**Recommendation Report for Listed Building Consent for Alterations, Extension or Demolition of a
Listed Building**

REF NO: Y/42/26/L

LOCATION: Bonhams Farm House
Main Road
Yapton
BN18 0DX

PROPOSAL: Listed building consent to add channel drain across the front elevation in front of the stable space, add wood floor and battens over new bed 2 (former garage) and stable floor, replace main stable door with compliant painted double glazed timber door in similar style but with glazed panels in the top half and add removable slimline secondary glazing inside 3 retained timber windows in the stable space (resubmission following Y/39/25/L).

Drawing No.
KD.010D

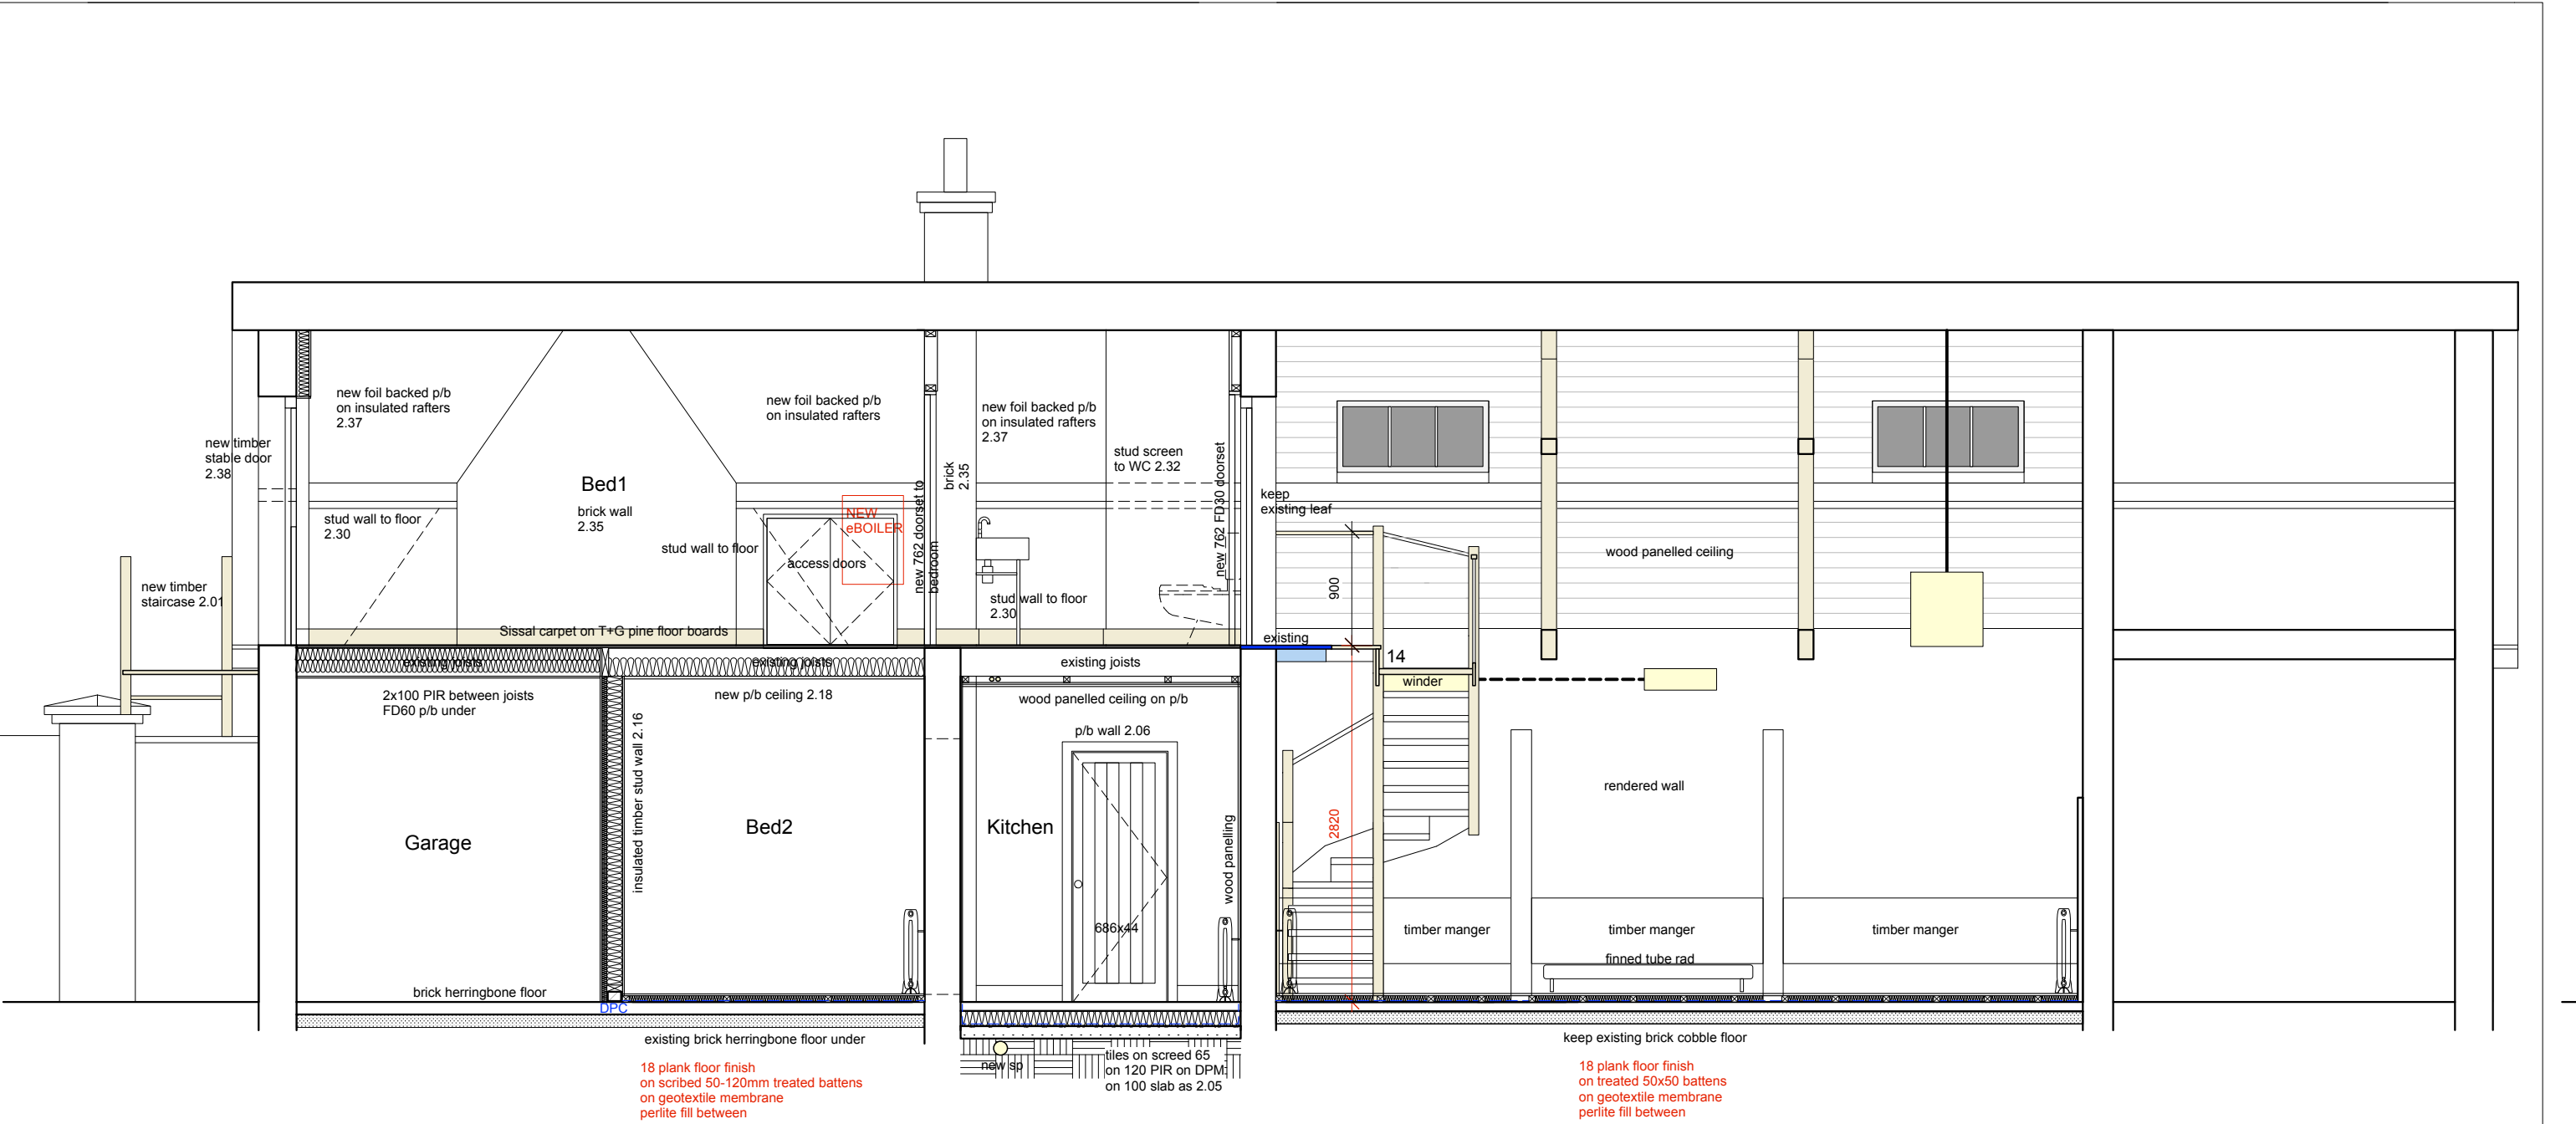
I would also wish to be reassured that the proposed timber flooring would not cause any harm to the existing floor, which is to be retained beneath. For instance, will it enable the floor to breathe and therefore not deteriorate as a result of trapped moisture? I would also want to be assured that no fixtures or fittings will be attached to the brick cobbles.

Comments noted. Further information was sought following the Conservation Officer's response. Having reviewed the information provided, the Conservation Officer states it appears that the proposed floor construction retains the historic brick floor in situ beneath the new flooring and has been designed using breathable materials throughout. The submission also states that the geotextile membrane will prevent the insulation fill from clogging the joints between the historic brick setts, thereby preserving the historic floor for future reversal. On the basis of the information submitted, I have no conservation objection to the proposal.

Stable front door

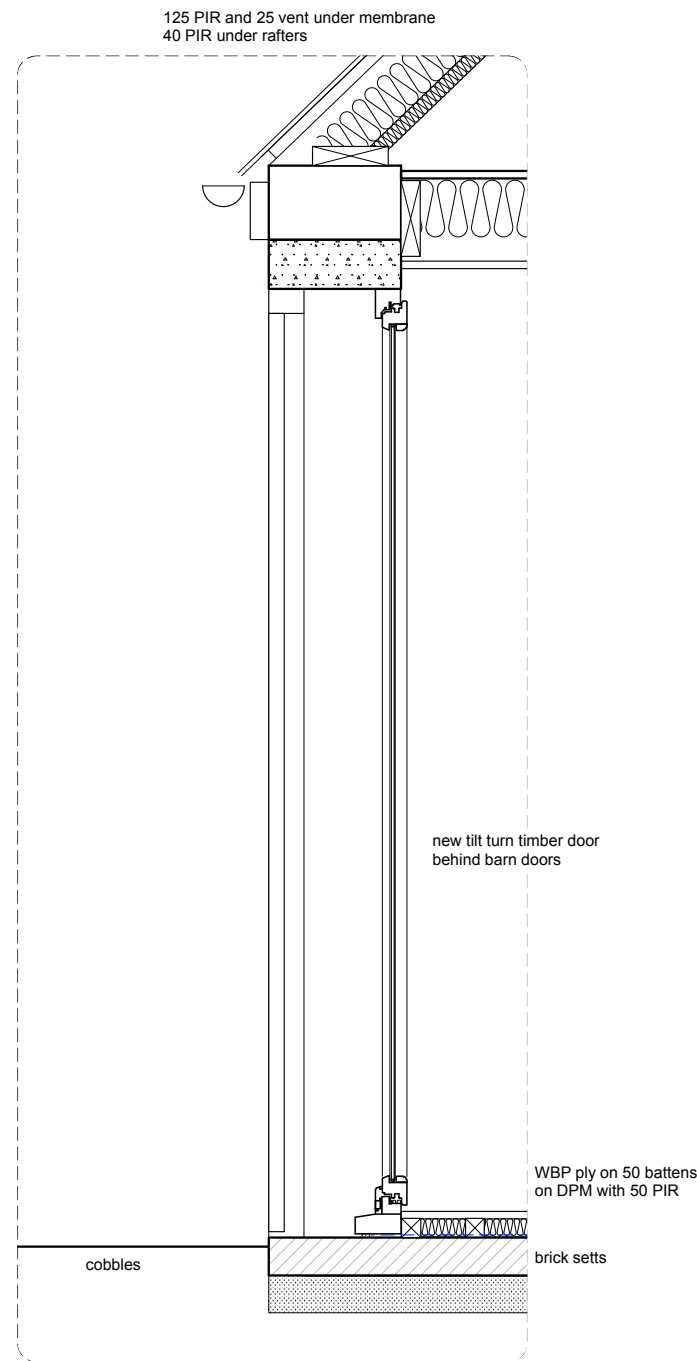
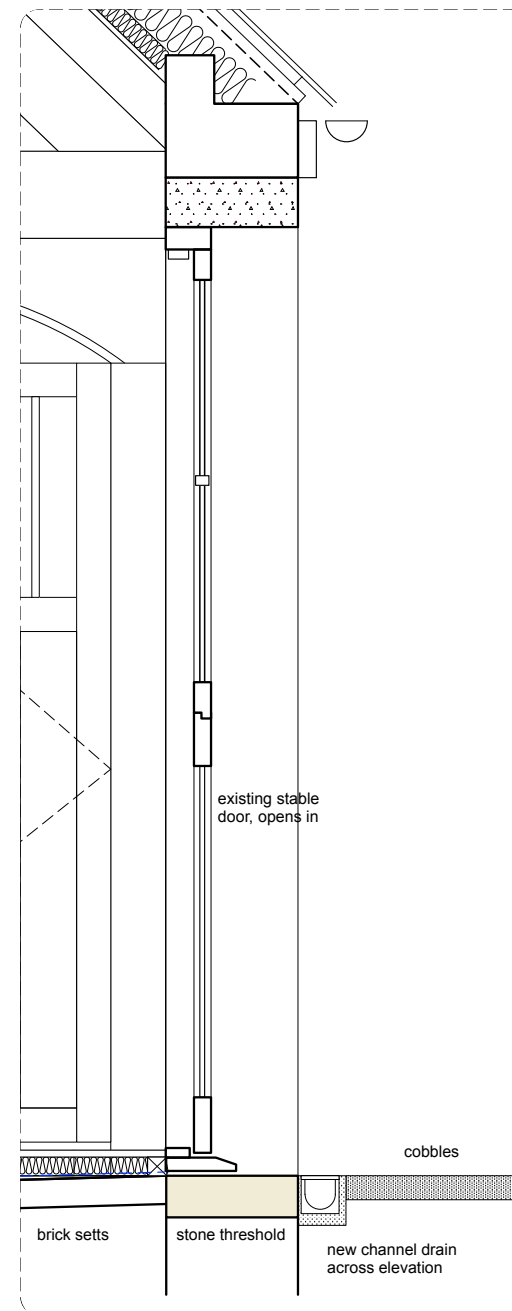
Whilst the revision to the approved scheme would look to be acceptable, it is not clear what the double-glazed timber door/window behind the garage doors would look like, as no elevations have been provided and only the closed garage doors are shown on the submitted drawings. Likewise, I will need to see further information on the new stable door. I have requested a condition.

Furthermore, the condition requiring door details is no longer required, as the additional elevations appear acceptable. It is noted that the new bedroom window/door openings are preferred with a flush design.
